From: Julie Grieves on behalf of Planning.Responses
Sent: 19 July 2019 10:21
To: Planning Scanning
Subject: FW: Planning Application for 2no. additional dwellings to 6 Manor Road, Rustington
Attachments: elevations.pdf

From: Mark
Sent: 18 July 2019 11:20
To: Anita Gardner
Subject: RE: Planning Application for 2no. additional dwellings to 6 Manor Road, Rustington

Having reviewed the change we still wish to **object** to the proposed application for two additional detached dwellings to 6 Manor Road.

DRAWING: PROPOSED NEW DWELLINGS - PLANS **SCALE:** 1:50 @ A2 **DATE:** 11/07/2019 **DRAWING No:** DS/6MANOR/04 rev 2

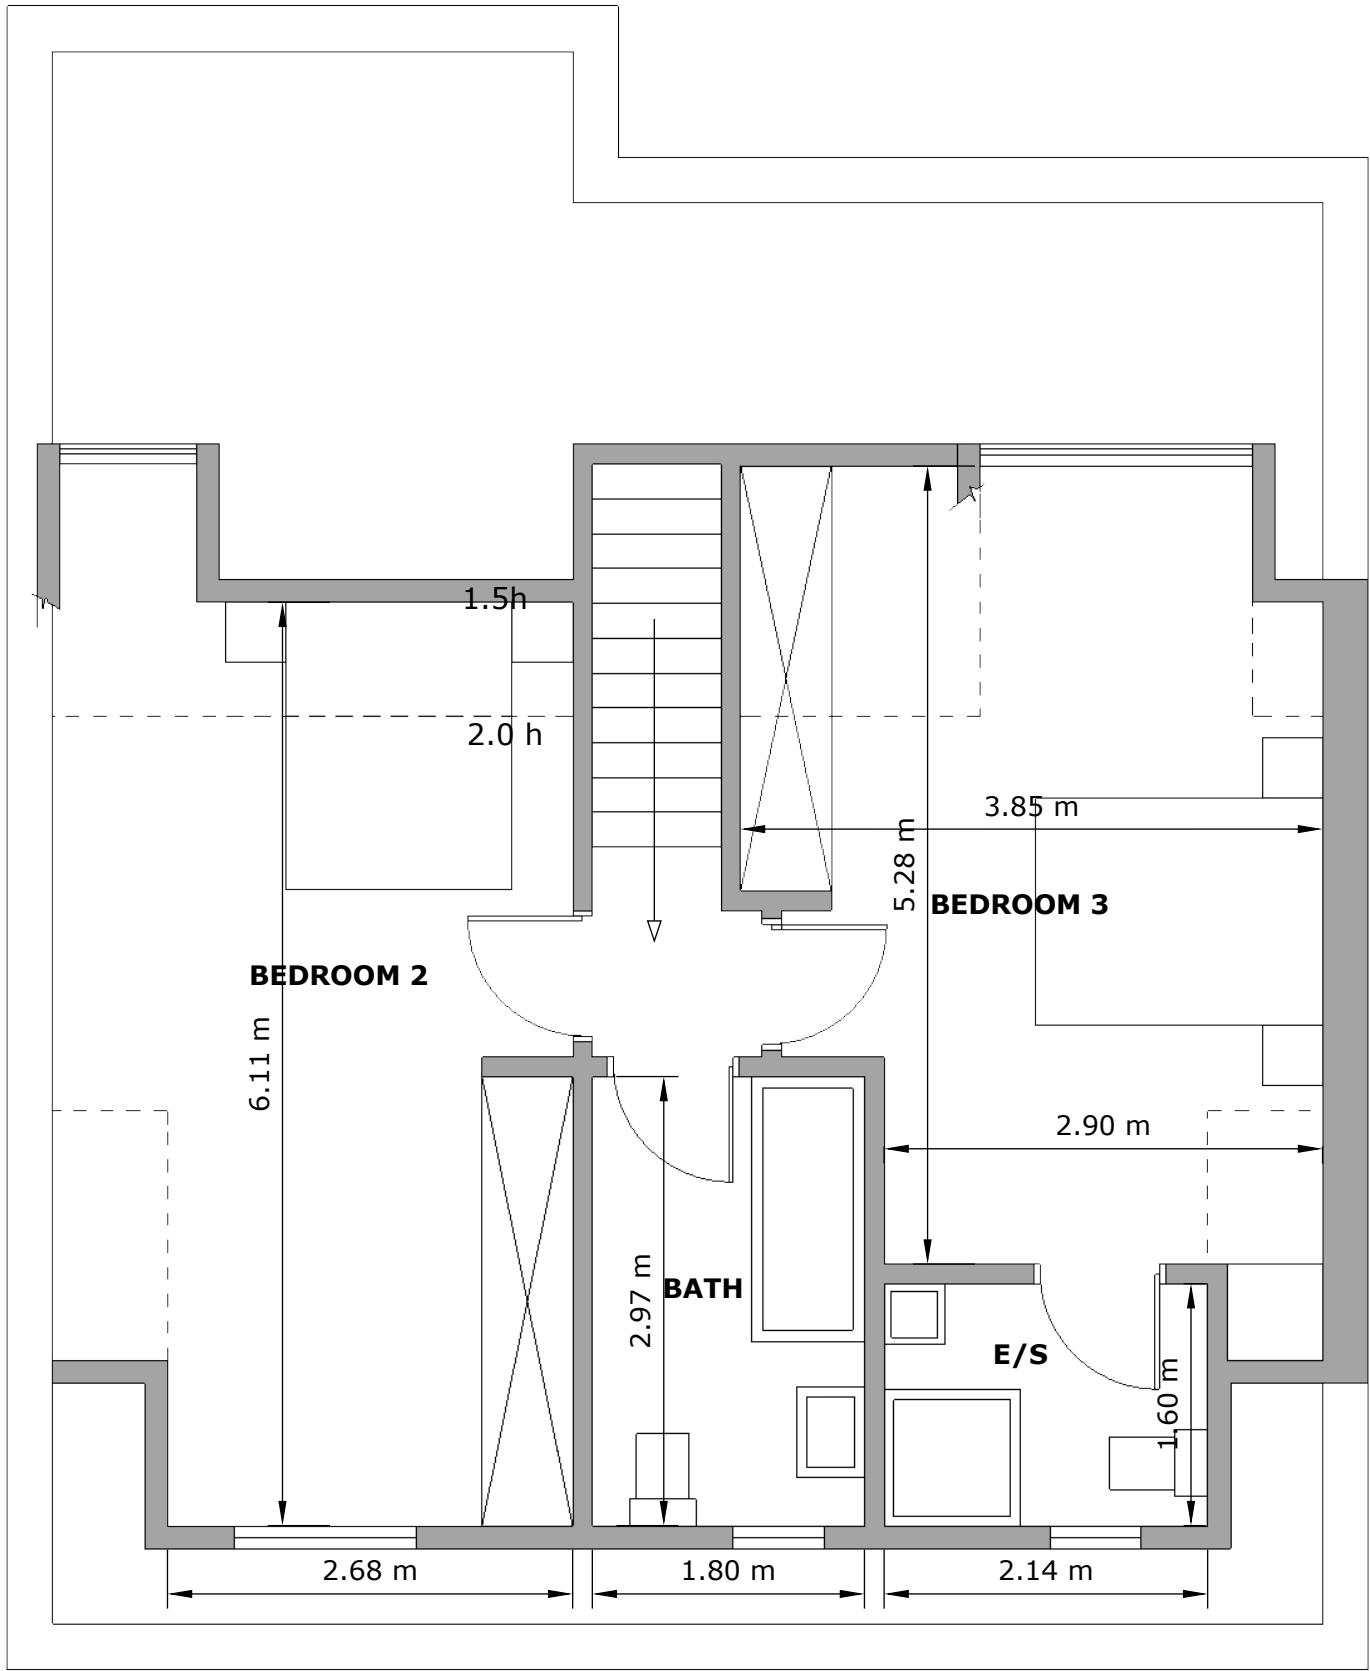
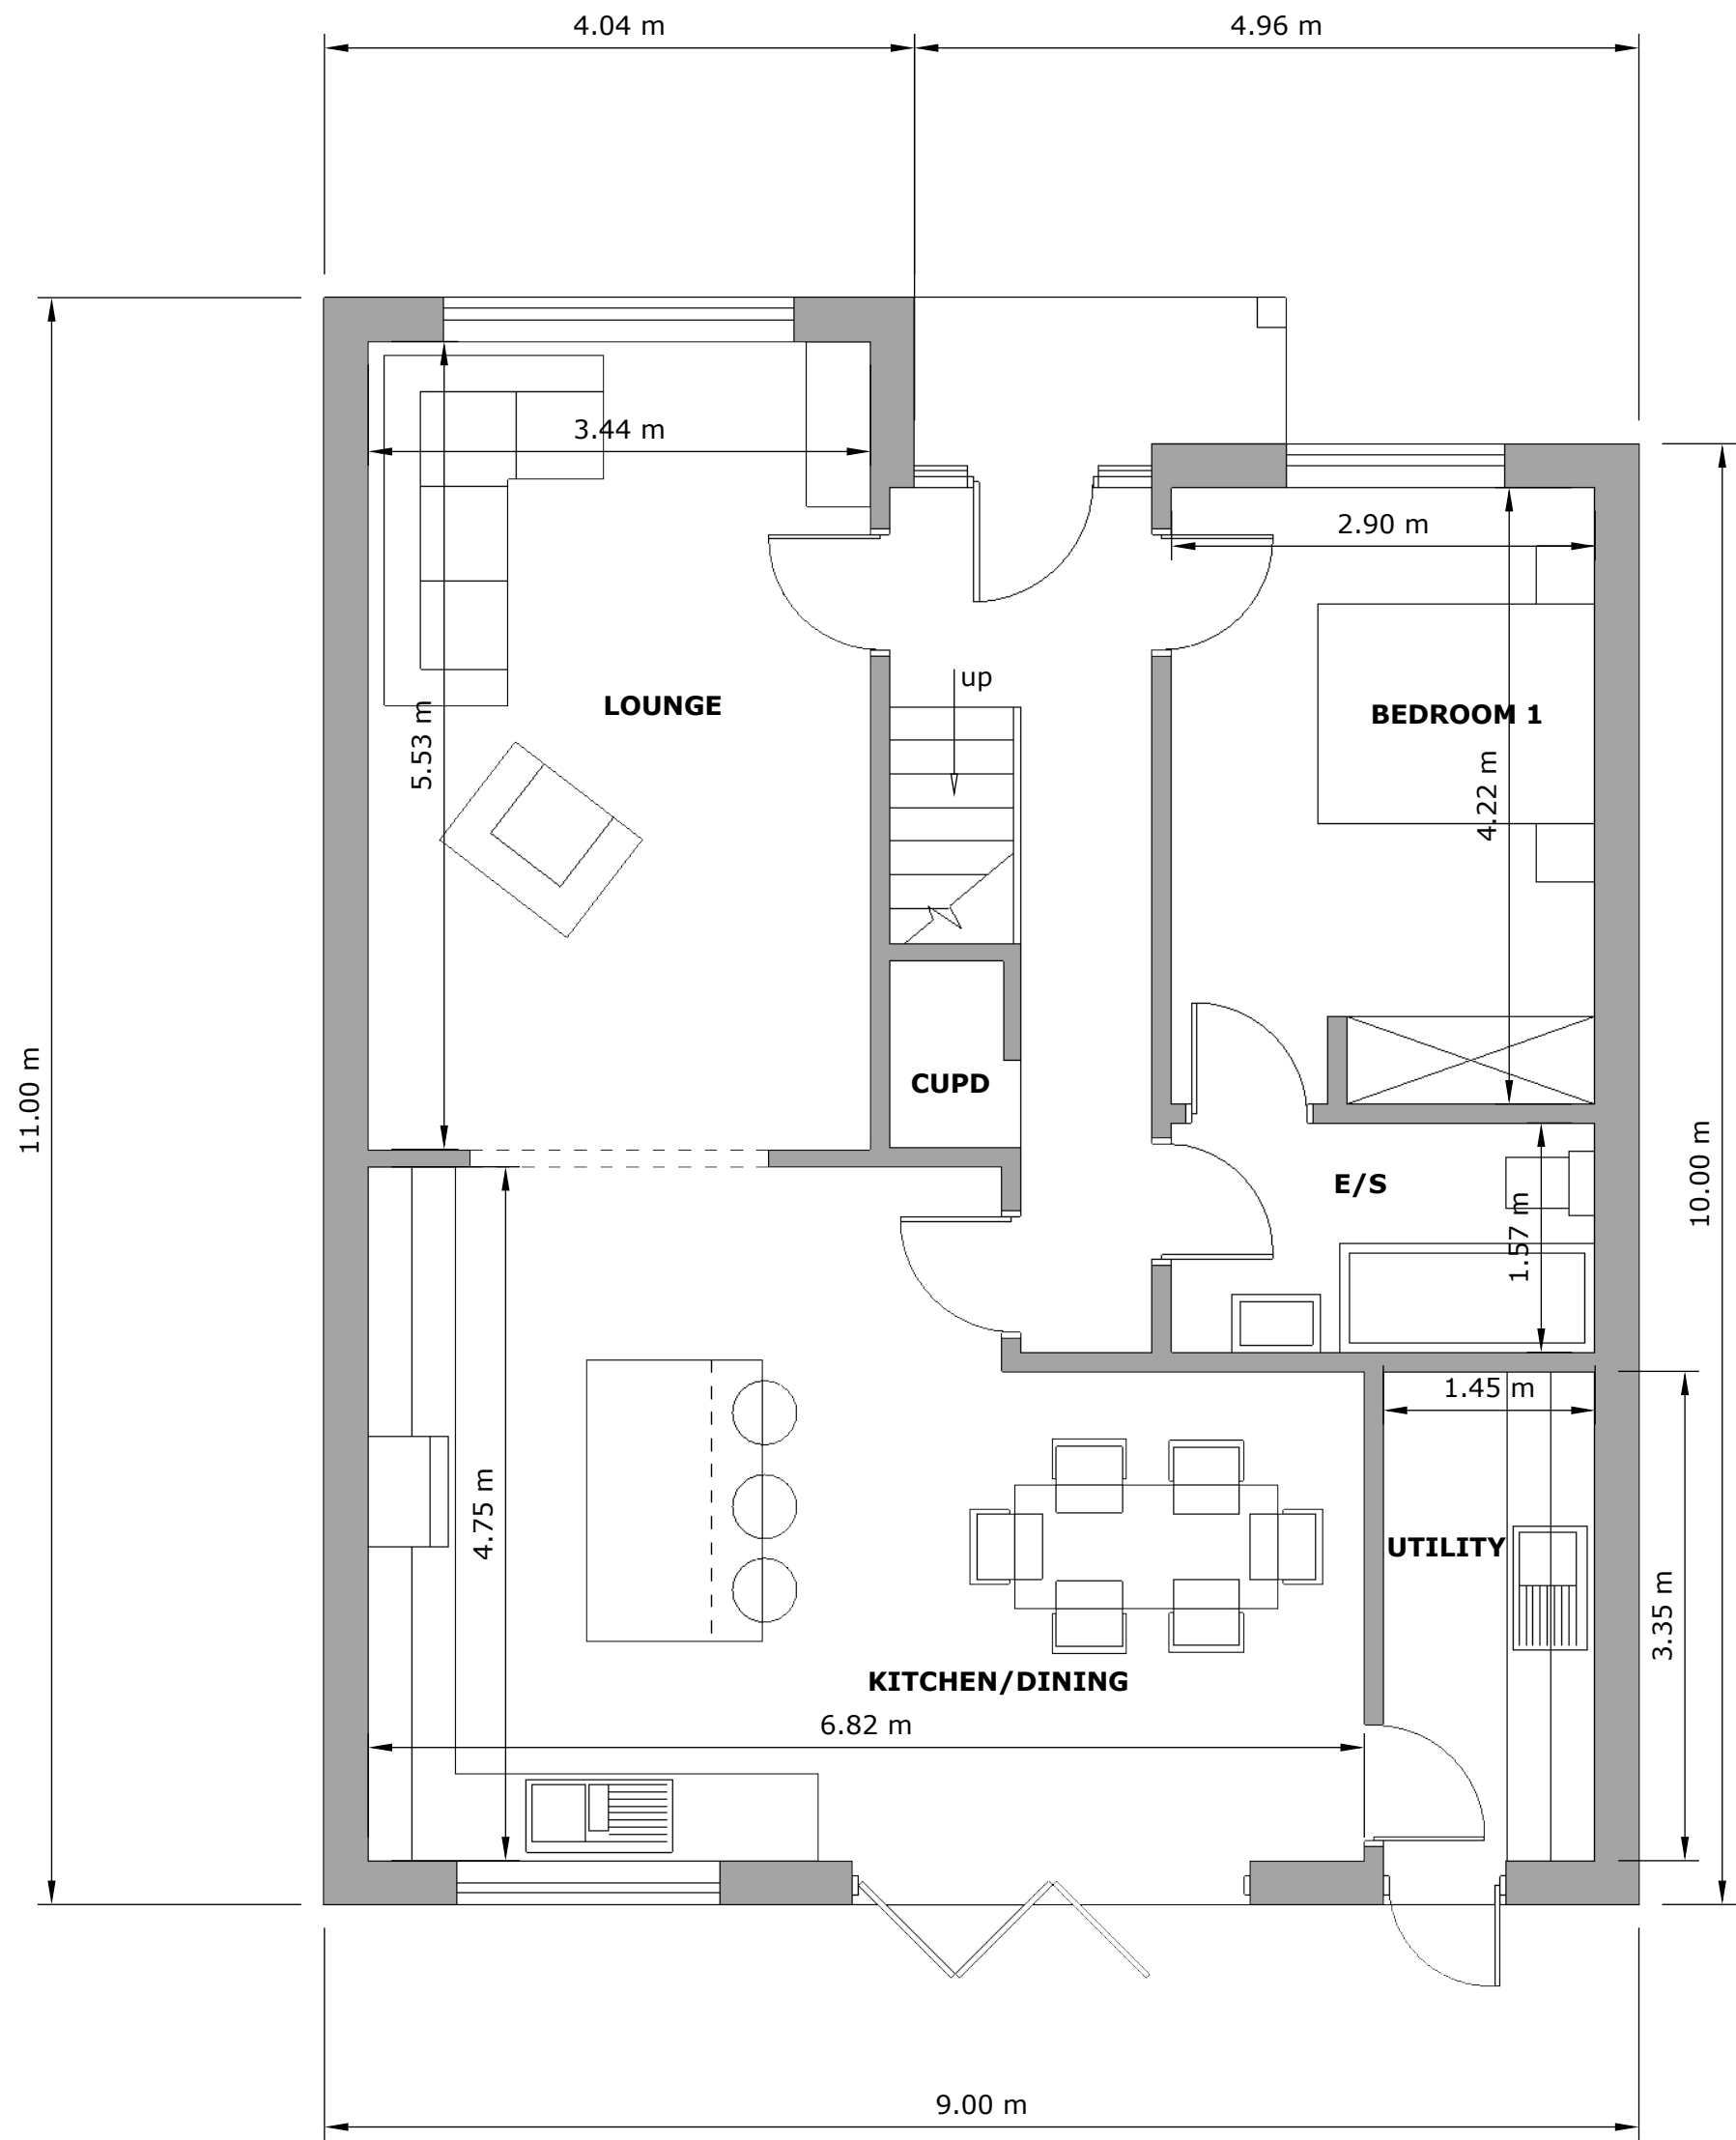
As far as we can see the only change is the removal of the small side window at first floor and creating a new first floor window with dormer roof extension to the front elevation.

DRAWING No: DS/6MANOR/03 rev 4

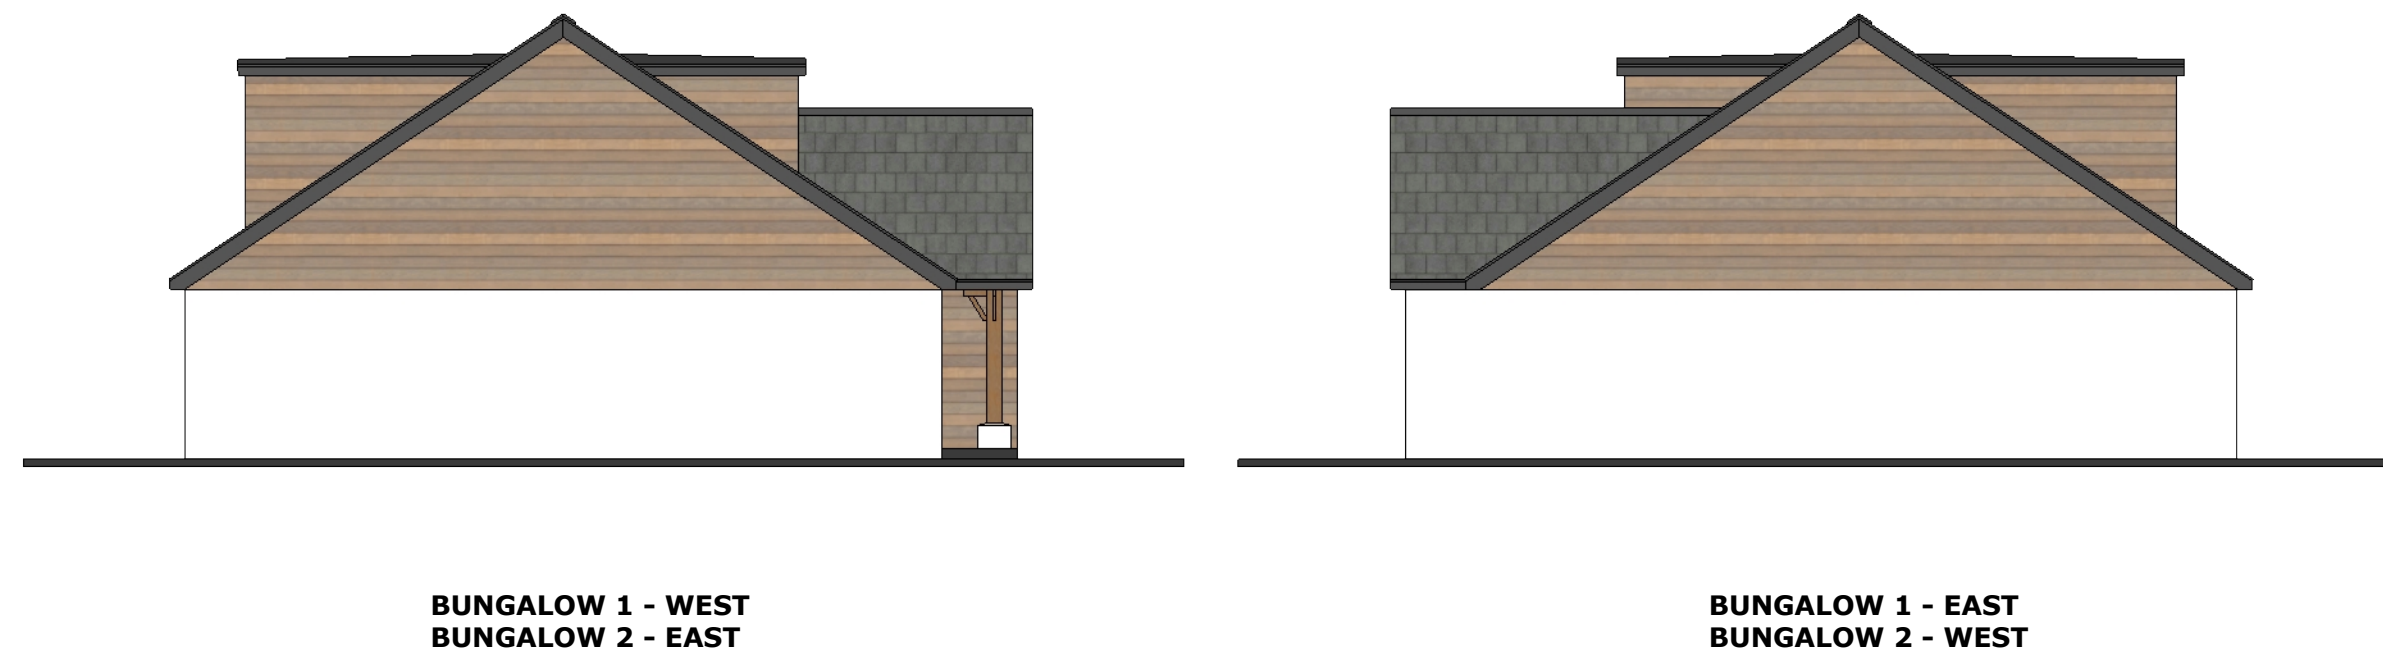
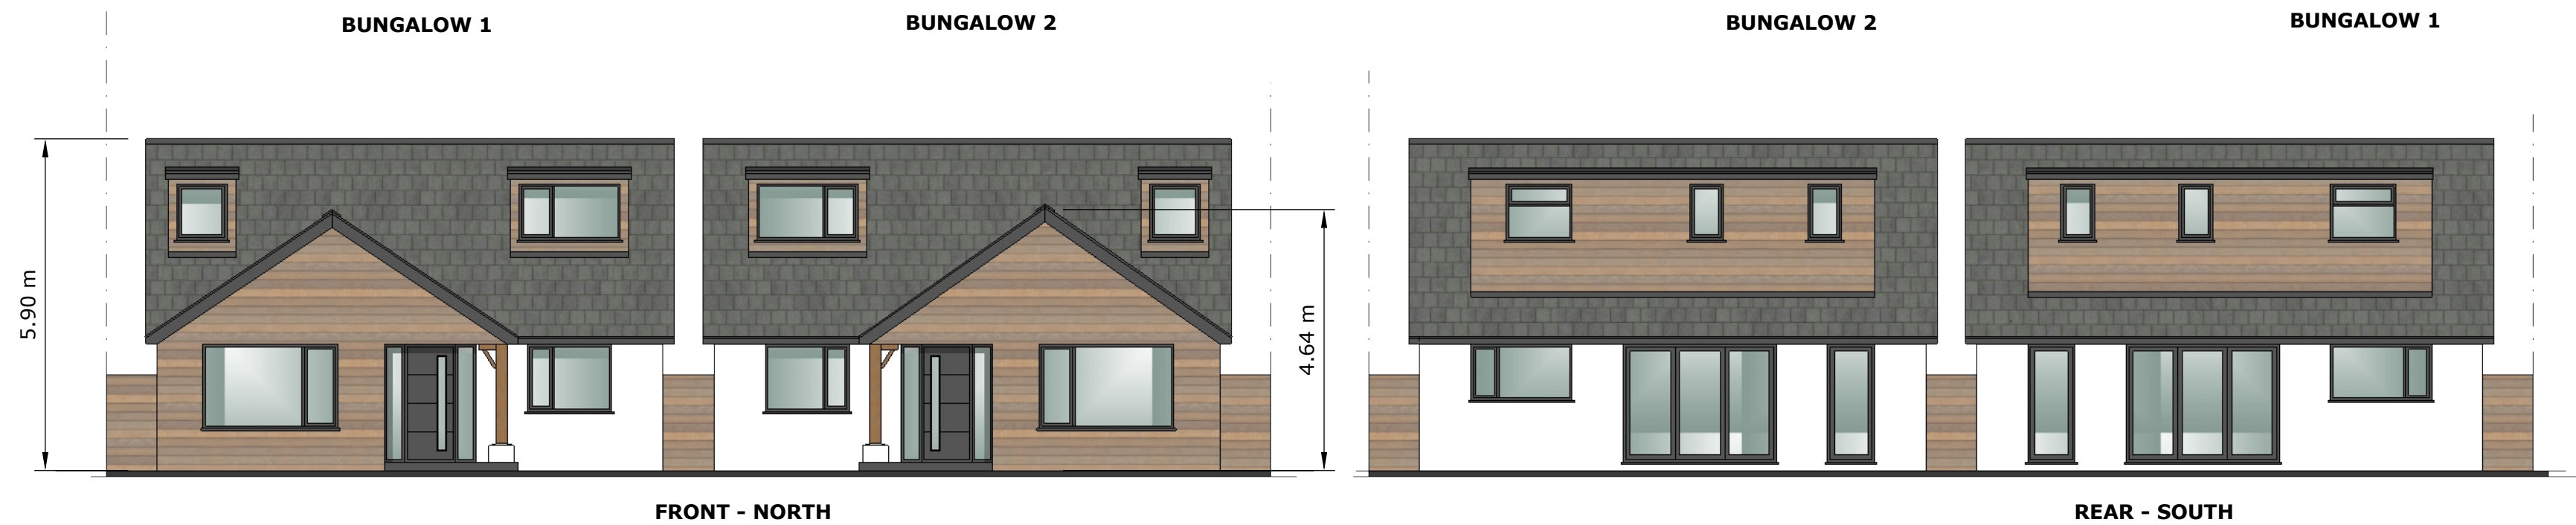
Our major concern is still how the design will impact us and be overbearing on us being the closest property to the proposed development and the fact that the new properties will still be nearly 1m higher than the existing bungalows with a height of 5.9m proposed, and positioned 1.5m in front of us and 1.5m behind us. Our bungalow is 7.98m deep and the new chalet bungalows are 11m deep. With the new property being so close to us, only 1.77m away, this will feel extremely overbearing and provide loss of light to us and have a negative effect on us living here.

The front entrance gable end projection alone is nearly as high as the existing bungalows at 4.64m.

A couple of points regarding the uploaded drawings, will there be an updated street scene drawing as I could not find it, only the old one with the old scheme elevations and secondly, the new bungalow 1 east elevation/bungalow 2 west elevation appears not to be shown correctly as it does not show the new dormer window extension in front of the lower gabled front extension of the property like it should (please see attached drawing), which will be visible from our side and the opposite side of the site.
